M5 JUNCTION 10 IMPROVEMENTS SCHEME – TR010063

Section 51 advice regarding draft application documents submitted by Gloucestershire County Council

On 18 November 2022, Gloucestershire County Council submitted the following draft documents for review by the Planning Inspectorate as part of its Pre-application Service¹:

Figure 3-4 - West Cheltenham Link Road Route Corridors

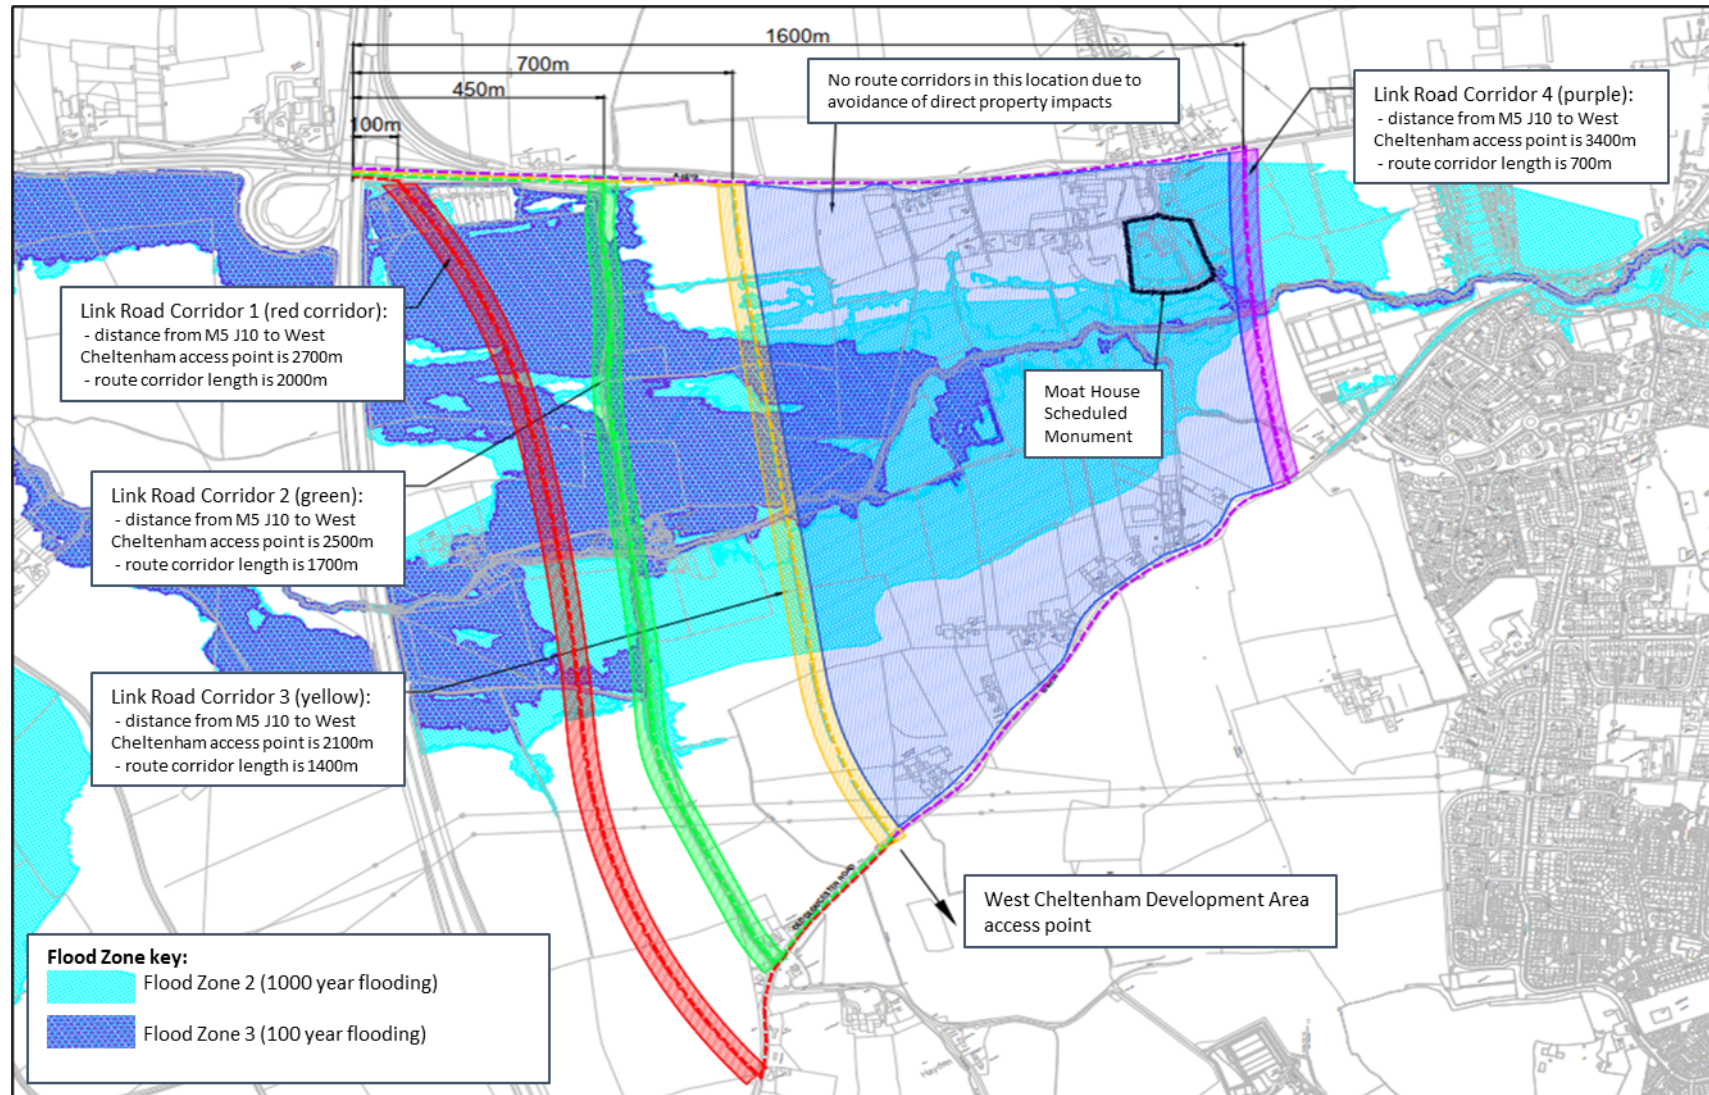
37.	Figure 3-2	The Applicant may wish to clarify the title of this figure to make clear this represents the “Options 1A, 2, 2A, 2B and 5 for the M5 Junction 10 Improvements Scheme (without earthworks)”, as stated in the ES. The Applicant may also wish to include Figure 3-3 “West Cheltenham Link Road Route Corridors” as a standalone figure rather than embedded in the ES text, for clarity.
